**WEST SUSSEX COUNTY COUNCIL
STRATEGIC PLANNING CONSULTATION**

SUBJECT: R/206/11-Putting tables & chairs outside front of shop.

8, Broadmark Parade, Broadmark Lane, Rustington, West Sussex, BN16 2NE

Title: PROPOSED GROUND FLOOR PLAN &
LOCATION PLAN & VIEWS

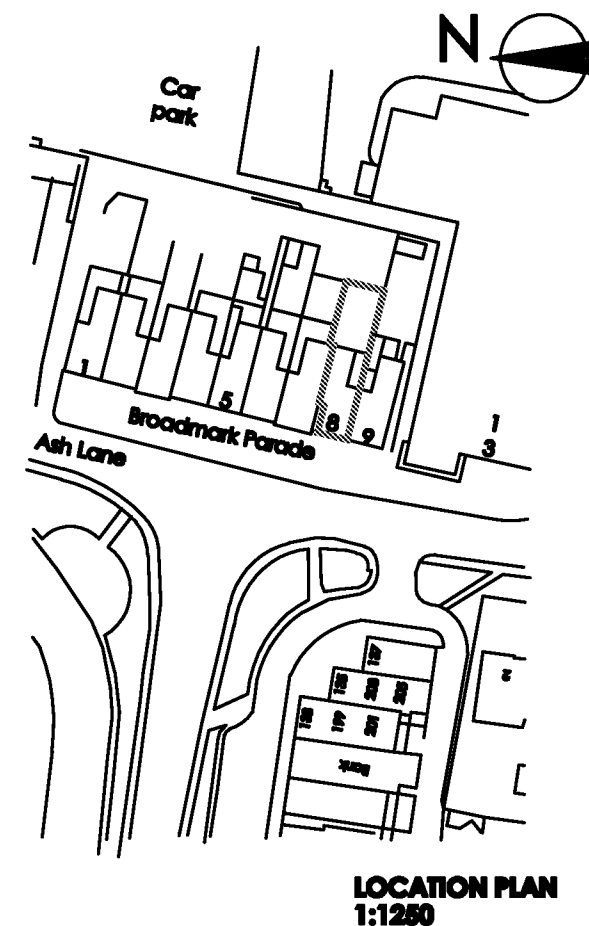
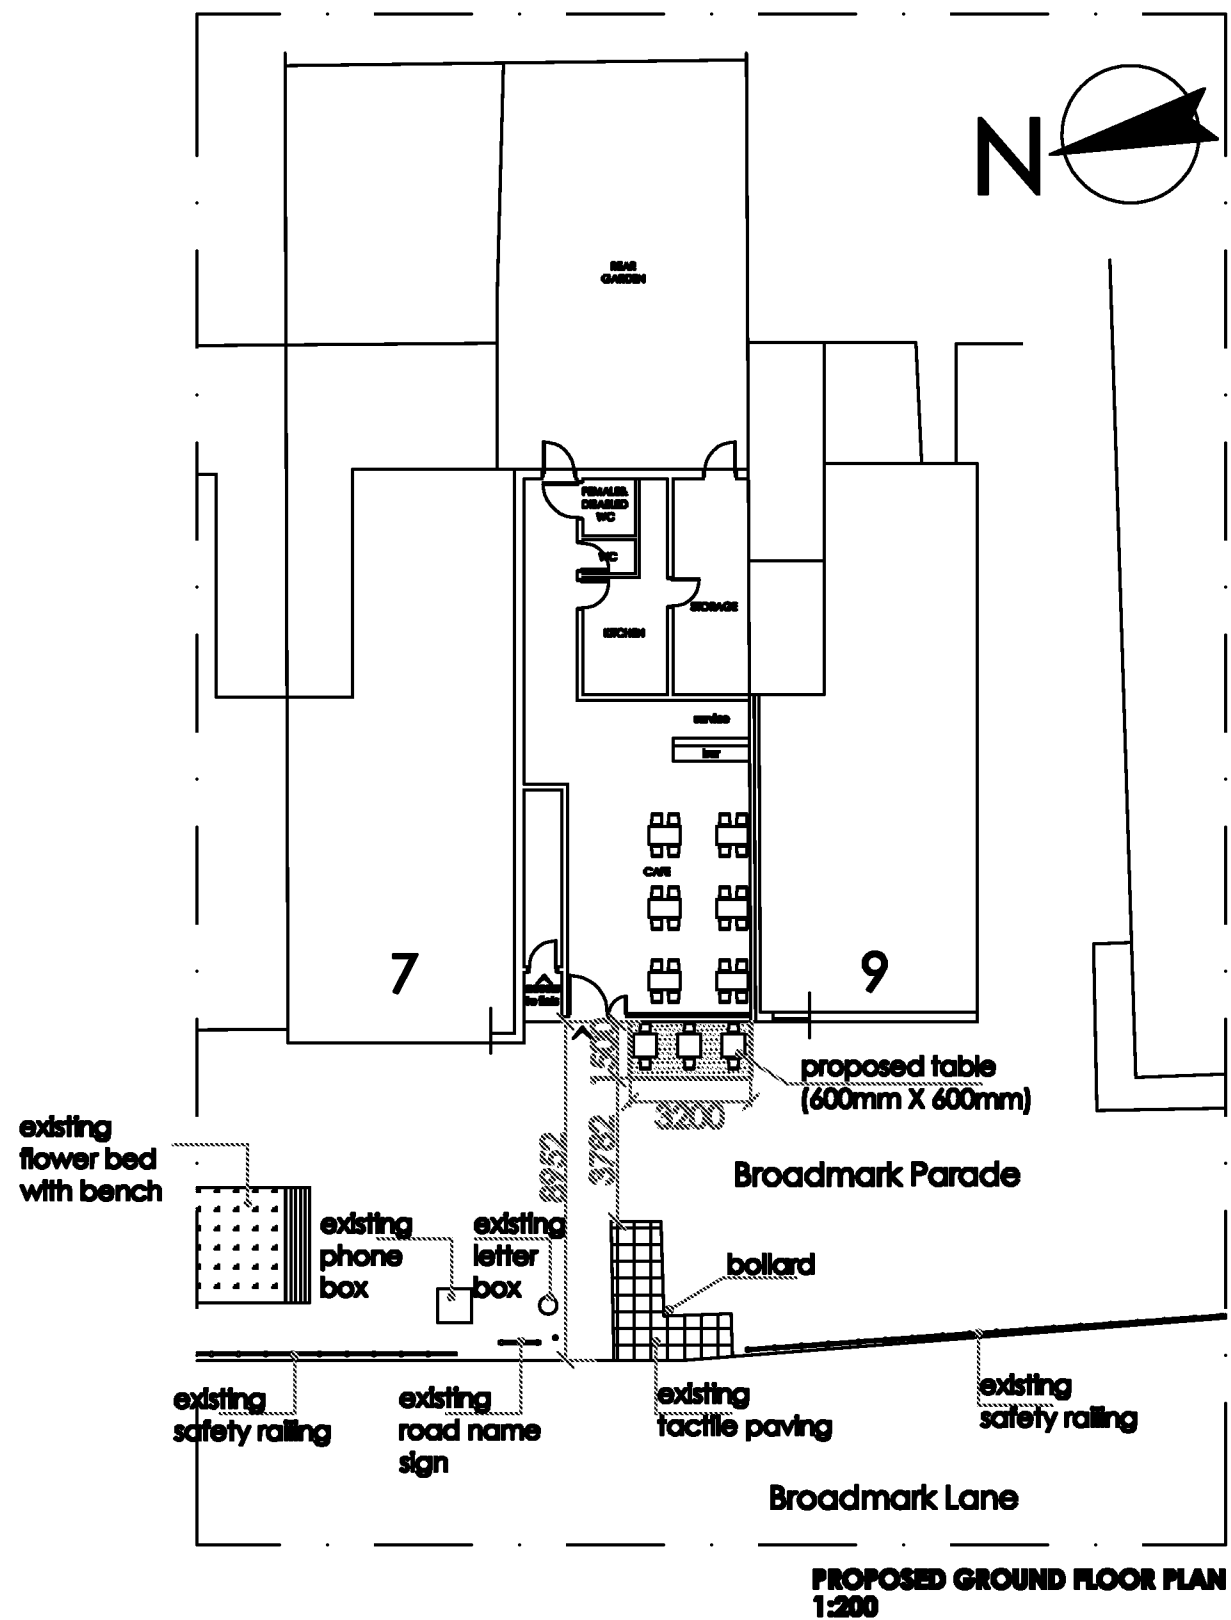
The items placed within the public highway are not to be permanently fixed and are to be removable. This is to permit the maintenance of the public highway and to ensure that a permanent obstruction does not result. If Planning Consent is approved, a separate Licence agreement will be required to be entered into with the Highway Authority, WSCC. It will be a requirement of the Highway Licence that tables and chairs must be removed from the highway each and every night and only placed out at times stated within the Licence agreement.

The applicant is advised to contact the Coastal Team, Community Development and Big Society, Communities and Infrastructure Directorate, Centenary House, Durrington Lane, Durrington, Worthing, West Sussex BN13 2QB to obtain a license for the items that will be placed in the highway.
